<b>TO:</b>	Jean Fraser, Planner	<b>DATE:</b>	1/25/2018
<b>FROM:</b>	Michael Guethle, PE; Ryan Wingard, PE	<b>PROJECT NO.:</b>	13982A
<b>SUBJECT:</b>	Bramhall St. - 22; MMC East Tower and Visiting Parking (PEZ.2017.289)

Wright-Pierce has reviewed the Level III Site Plan Application information provided for the East Tower and Visiting Parking redevelopment proposed at 22 Bramhall Street. The project will include adding three levels of parking to the existing parking garage, relocating the heliport to the East Tower, and adding 2 floors to the East Tower. The work will add 0 square feet of new impervious surfaces, will add 0 square feet of new building surfaces, will add 225 parking spaces, and will add 137,961 square feet of building floor area.

SHEET 6
SHEET 7 SHEET 8

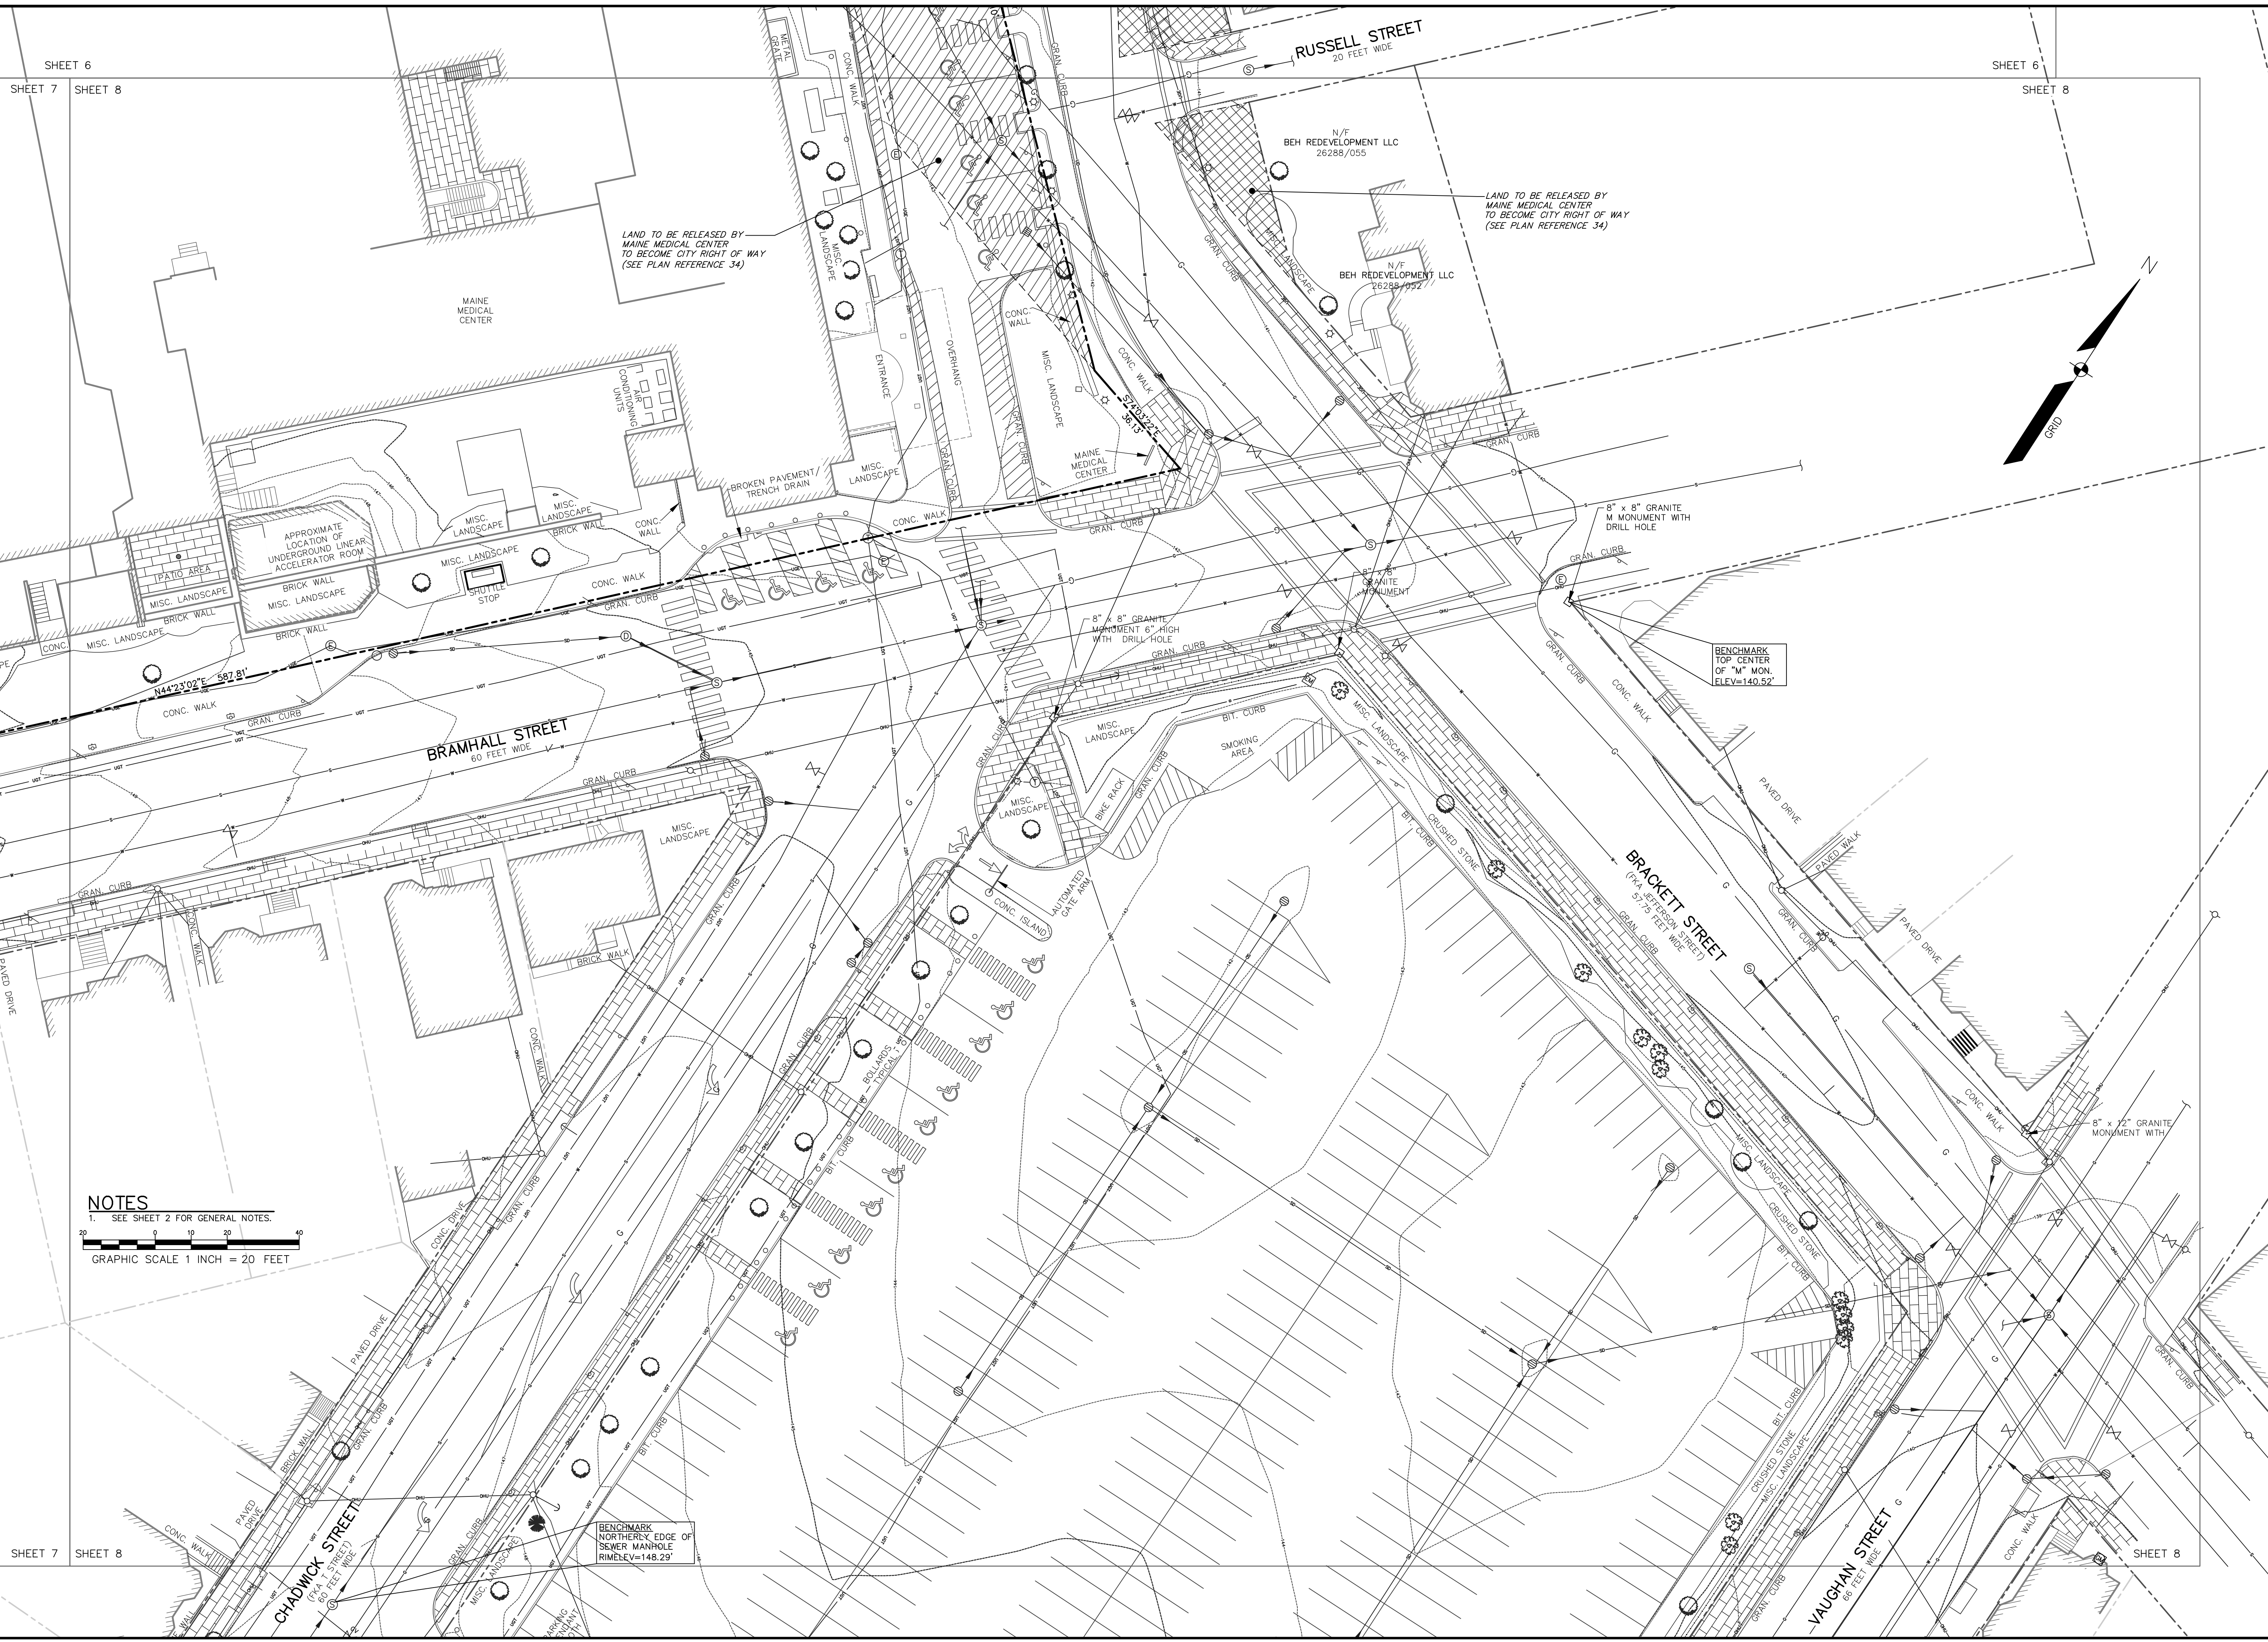
- ii. Plan 2D Boundary Survey indicates a connection or stub connection leading from the catch basin on the south side of the Visitor Garage that may allow for connection from the Visitor Garage roof drain into the separate storm drain system. The applicant shall provide the following:

1. An updated boundary survey in the vicinity of “Plan 2D Boundary Survey” with utility elevations, pipe sizes, and pipe materials in accordance with the City’s Chapter 14 and Technical Manual requirements for a Boundary Survey. Anecdotal information regarding the difficulty for construction in this corridor was discussed in the February 1 meeting. However, a sewer pipe crossing currently exists in this corridor, as does a storm drain or storm drain stub. City staff need additional information regarding existing utilities to confirm if a connection to the separate storm drain will be feasible or not.
